From: Mark Warwick
Sent: 14 May 2018 17:37
To: Simon Davis
Cc: Planning.Responses
Subject: RE: Tree Protection Plan - Sanderlings, 3 The Orchard Bognor Regis AW/55/18/HH

I have reviewed the Tree Protection Plan (TPP) dwg.no. 1035-5400, dated 27.04.2018 from Brigitte Crafer, Landscape Architect.

TREE PROTECTION PLAN - Sanderlings, 3 The Orchard
Scale : 1:100 @ A1

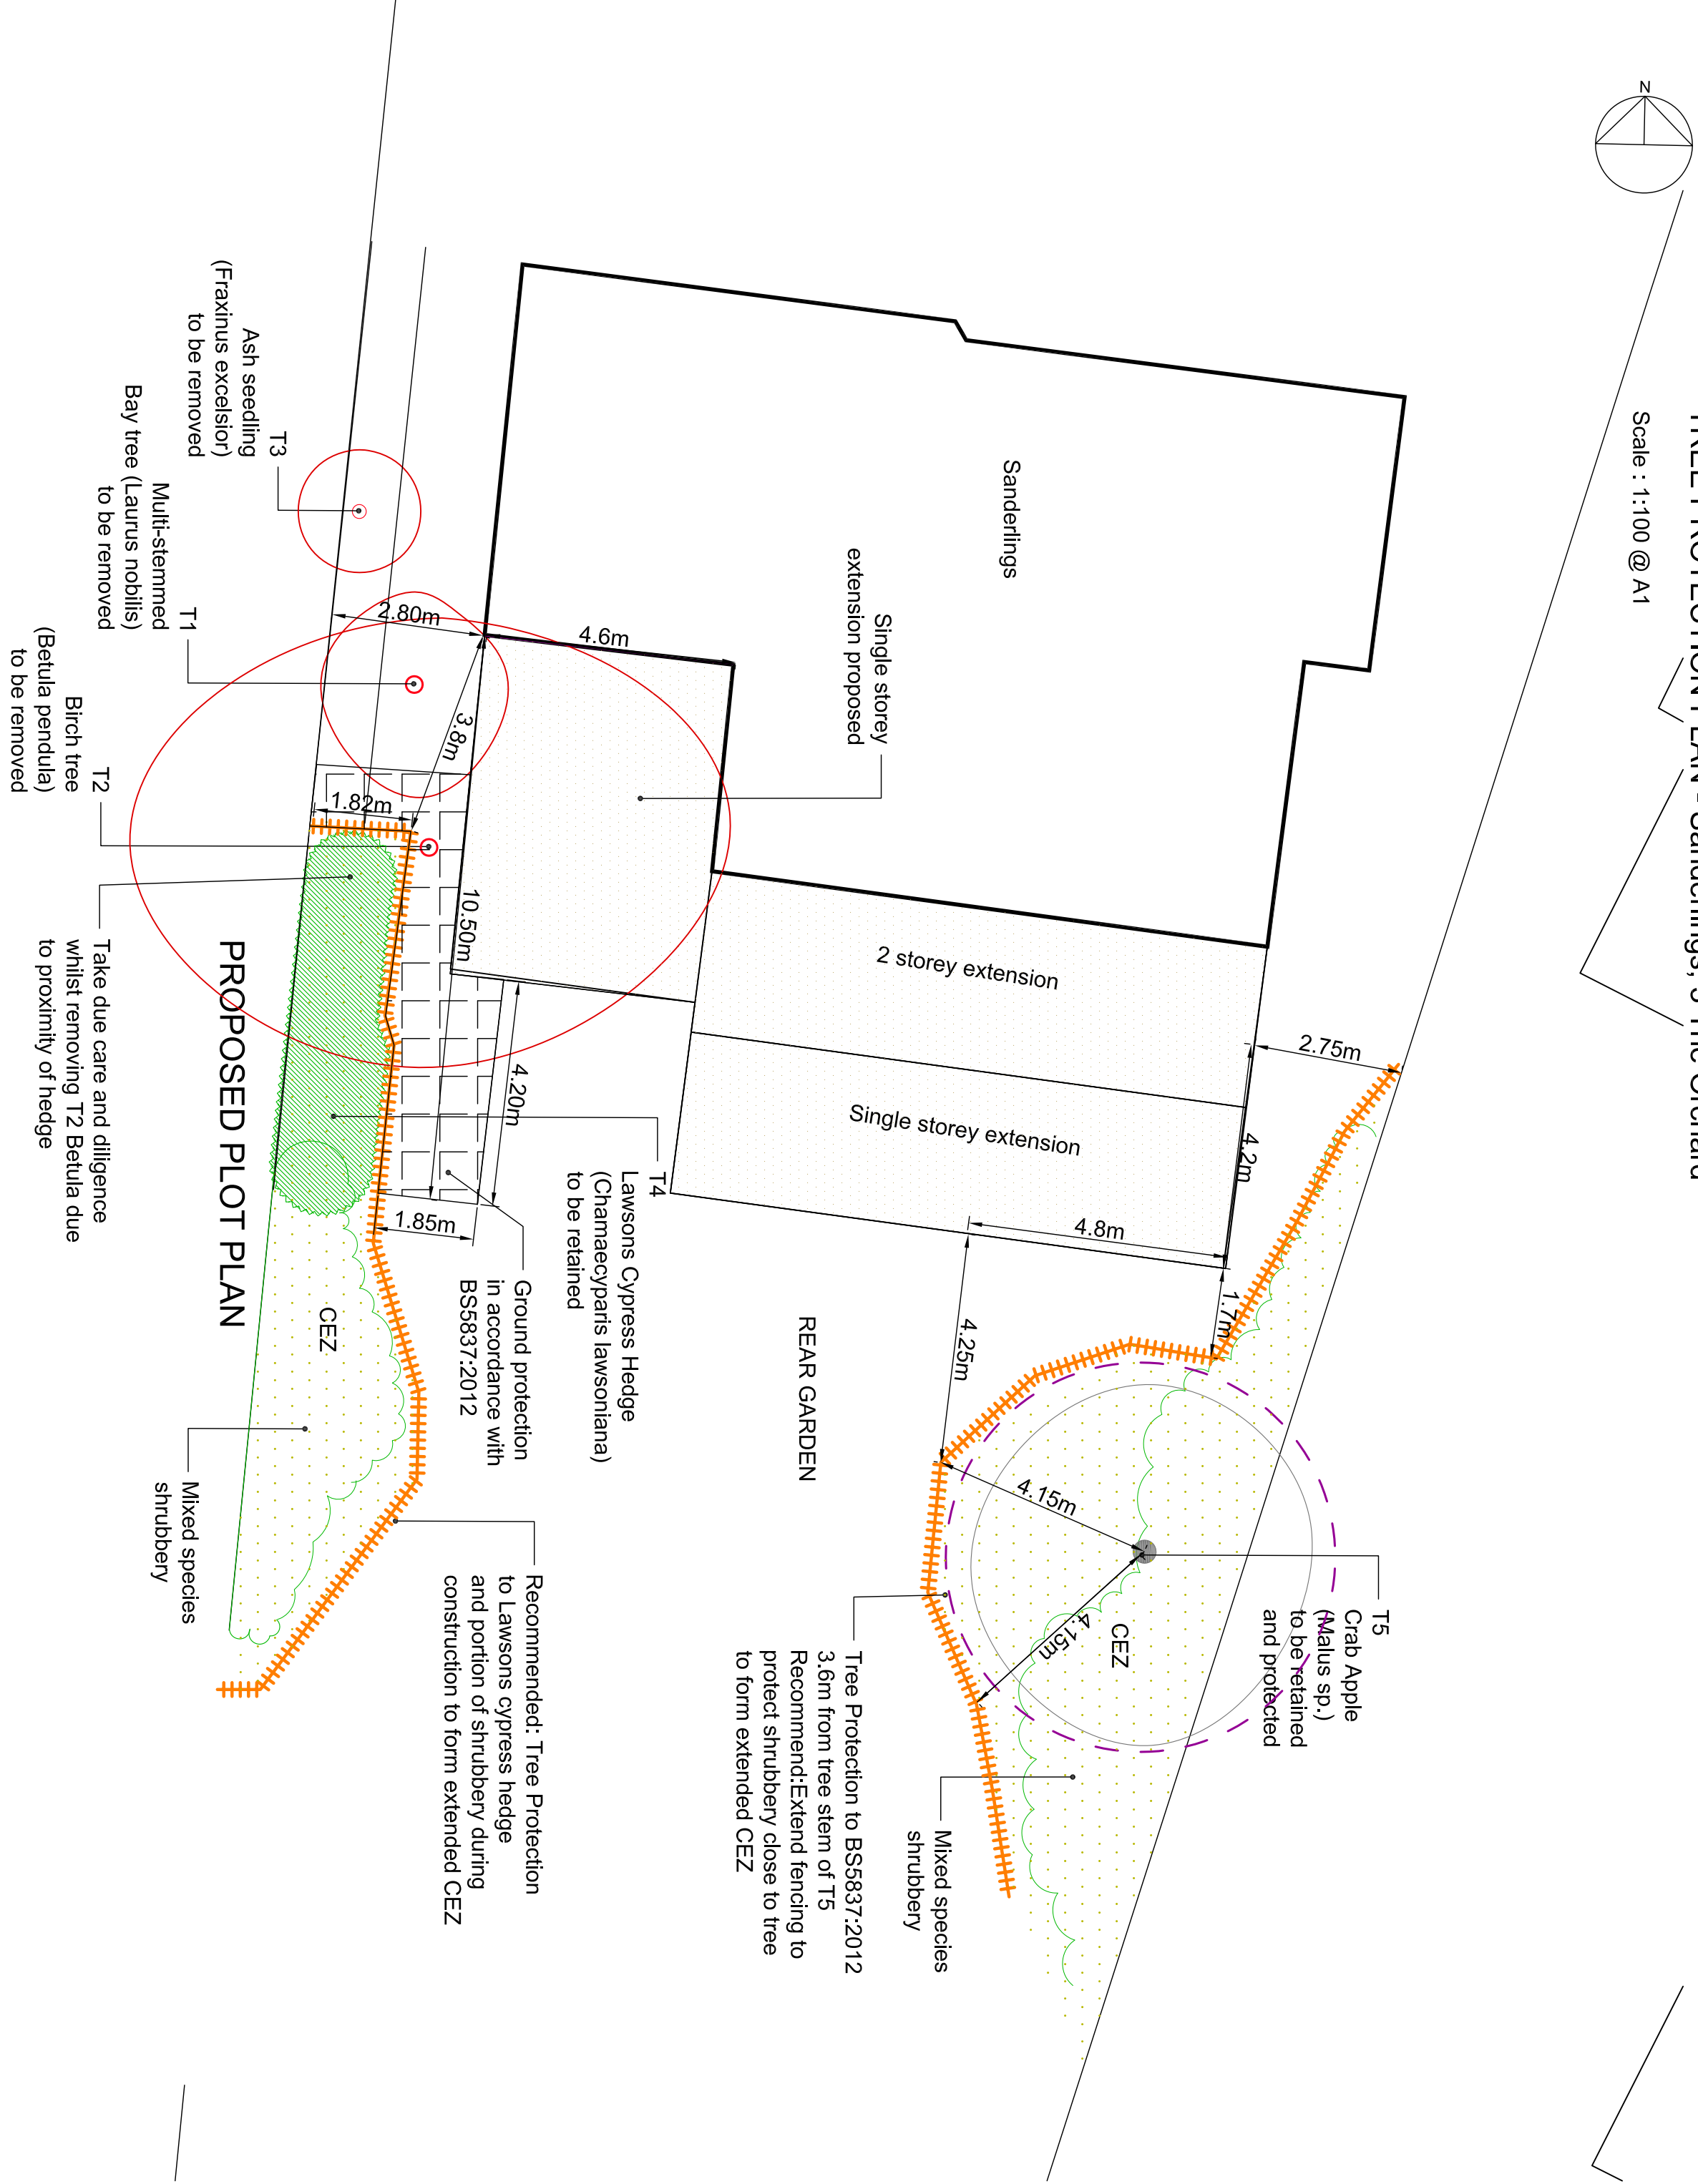
1. The TPP shows the position of Tree Protective Fencing within the Root Protection Area (RPA) of T5, where an opportunity exists to mirror the same and achieve full protection in accordance with BS5837 recommendations.
-This needs to be amended so that contractors working on site are able to clearly interpret from the drawing the required radial spread of protection and implement correctly.

2. The KEY on the drawing contains an anomaly that allows for mis-interpretation.
-The description alongside the symbol for Tree Protective Fencing needs to be corrected so that it describes the same.

3. The type of fencing proposed (orange plastic supported by road pins) is not going to be 'fit for purpose'.
- The fencing should be of a robust type that will resist impact from light construction plant, such as HERAS (BS5837, fig.2), securely fixed so as to form a construction exclusion zone. All panels should be double-clamped and tightened from the inside and securely sat in block trays pegged into the ground.
